Engineers Comments Regarding Surface Water Drainage

Application Reference:	A/30/26/PL	Reviewer Reference:	ADC/EXT5/AF
Planning Officer:	Kathryn Welch	Date of Review:	04/06/2026
Site Name:	Highdown Garden Centre Littlehampton Road Ferring BN12 6PG		
Application Description:	Demolition of existing open sided structures and erection of retail canopies and restaurant lobby. This application is in CIL Zone 3 (Zero Rated) as other development.		
Assessment Number:	3

Drawing No: A9803 - 140 P2

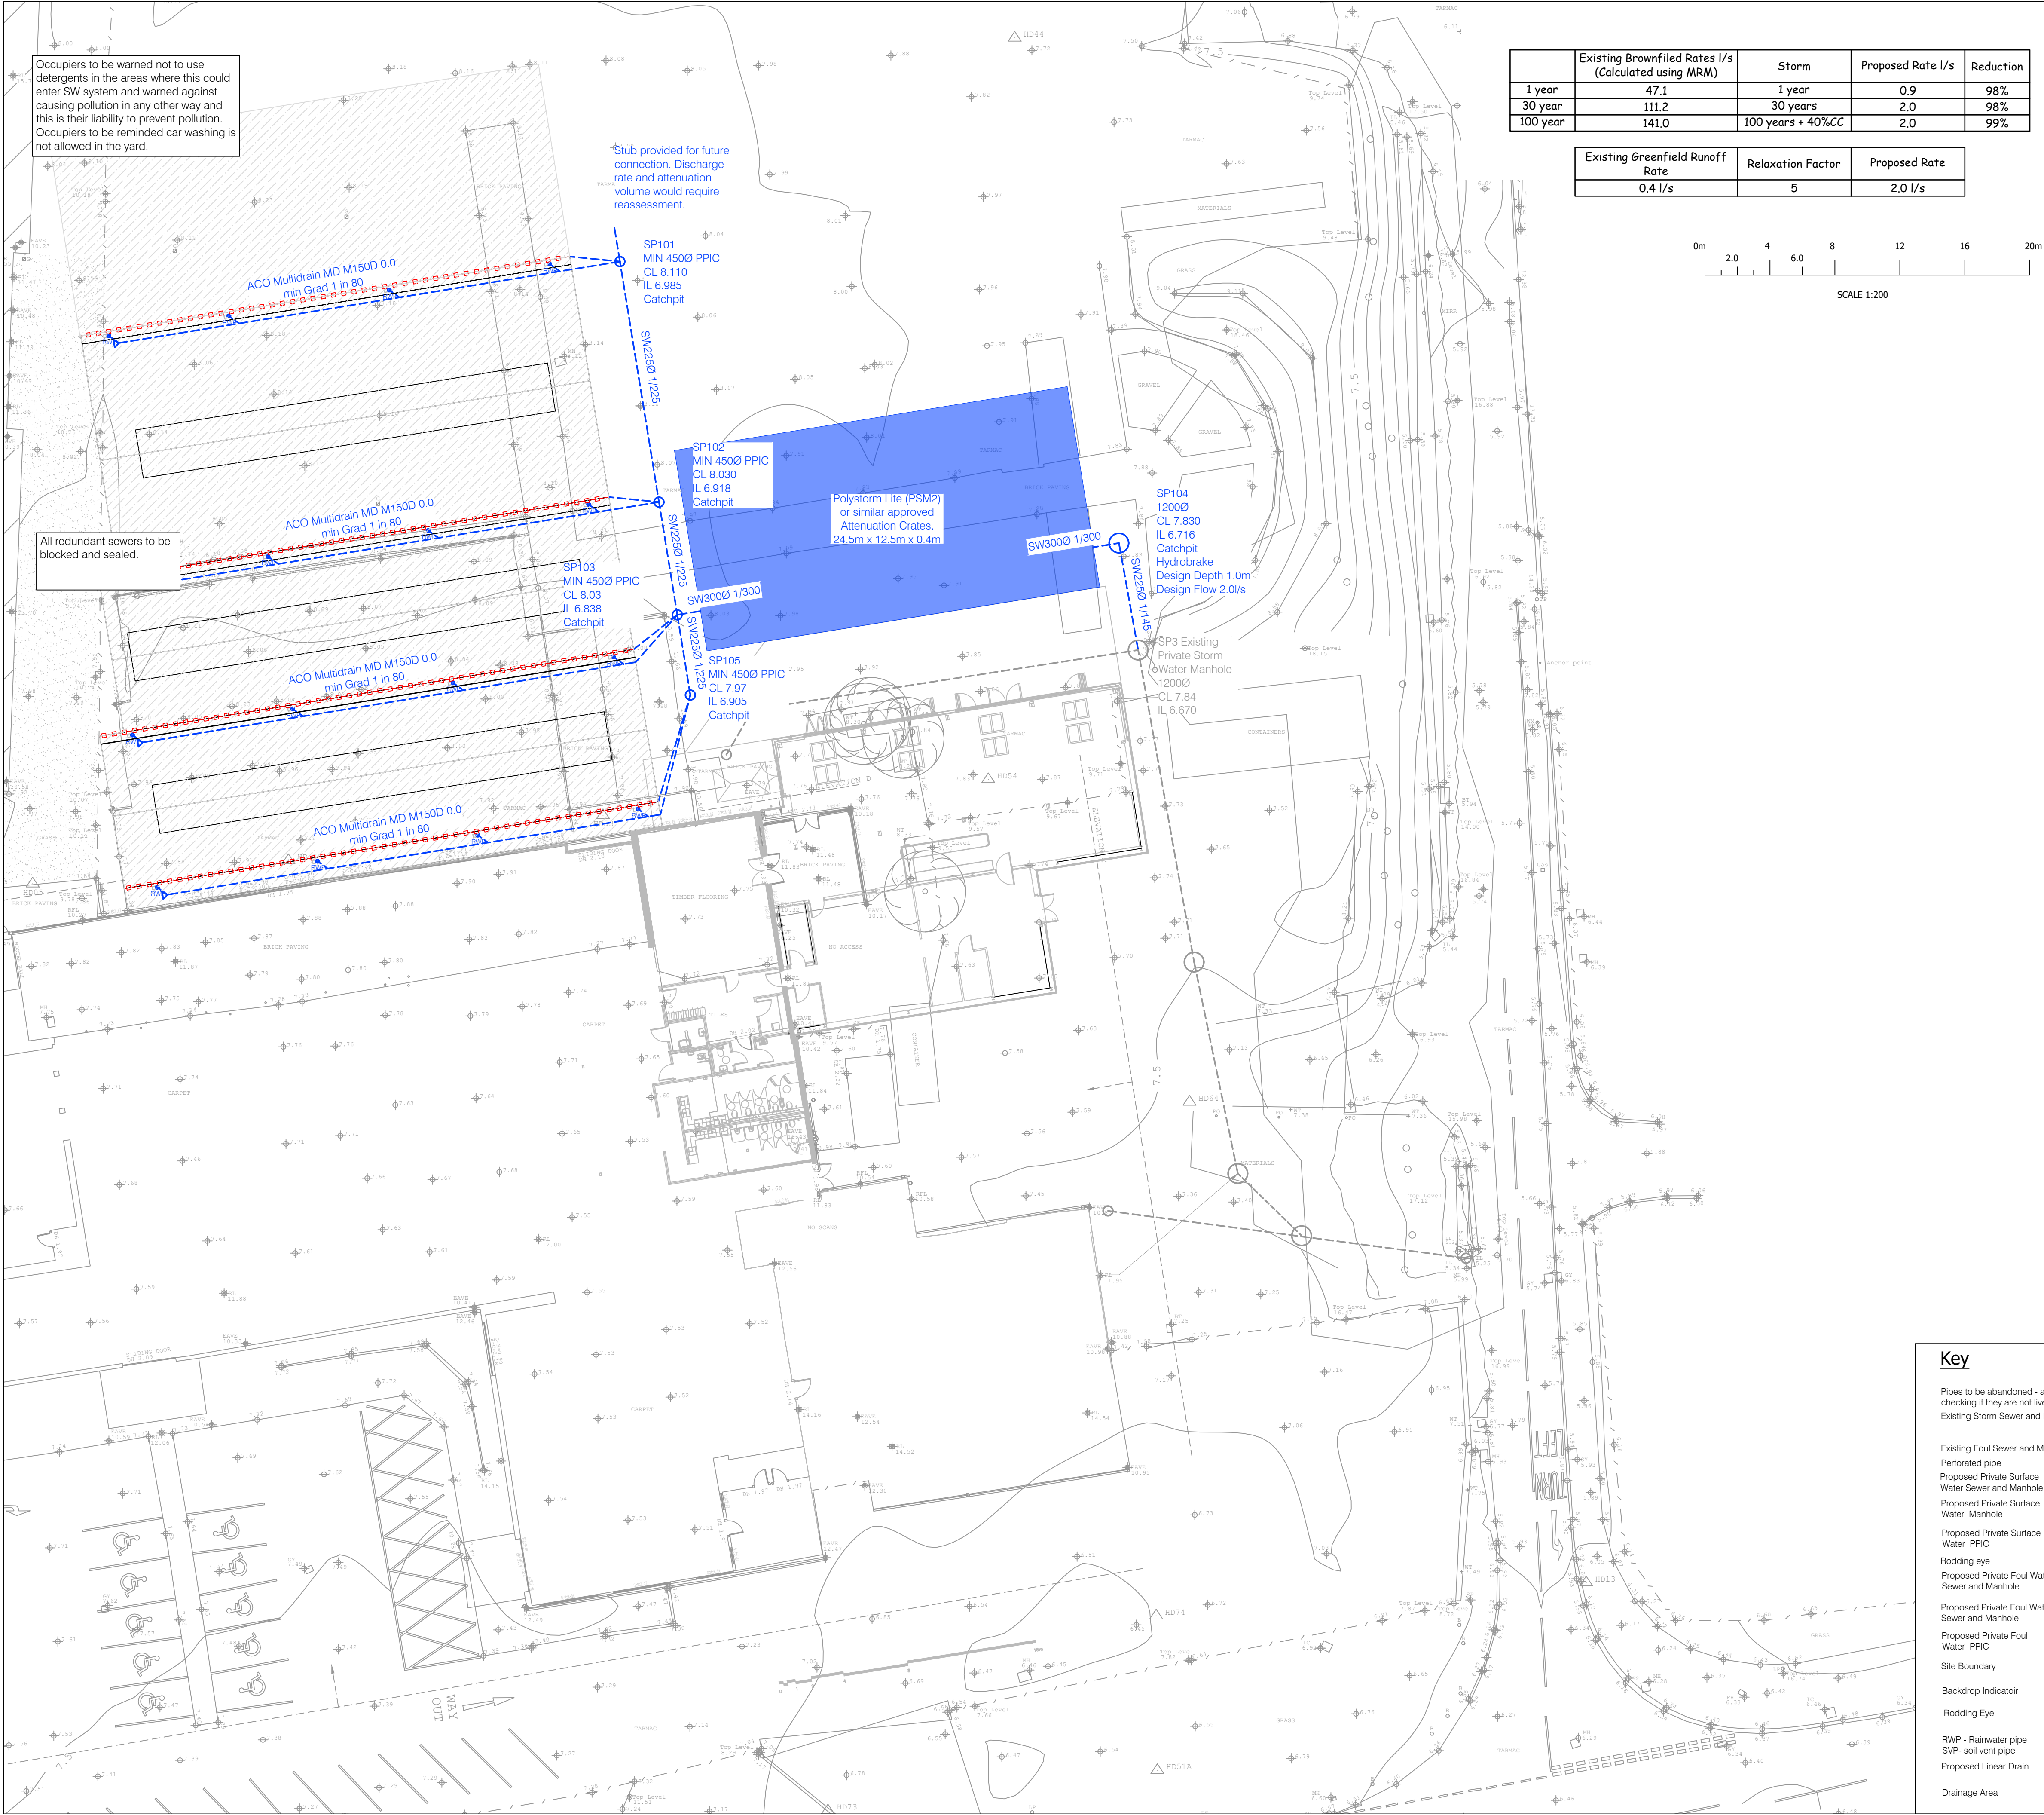
- 0.4. The Drainage Strategy email dated 30 March does not meet ADC guidance, further comments in the subheadings below. The Drainage Layout (A9803 - 140 P0) which contains some information but does not meet our standards for presentation and assessment of sustainable drainage. A Drainage statement should be submitted following guidance on ADC webpages - <https://www.arun.gov.uk/surfacewater>.

- 1.1. The proposed drainage layout shows a piped restricted outlet to the existing drainage system at the site. The downstream outfall is unclear on the plans but there is a piped ordinary watercourse shown on our records in the location.

2.1. Interception drainage is not currently incorporated into the design and is a requirement of sustainable drainage design.

3.1. We have reviewed the revised calculations dated 8 May 2026. The drained area in the calculations does not equal the area used for greenfield runoff calculations. A drained areas plan has not been submitted.

4.1. Water quality mitigation is not currently incorporated into the design.
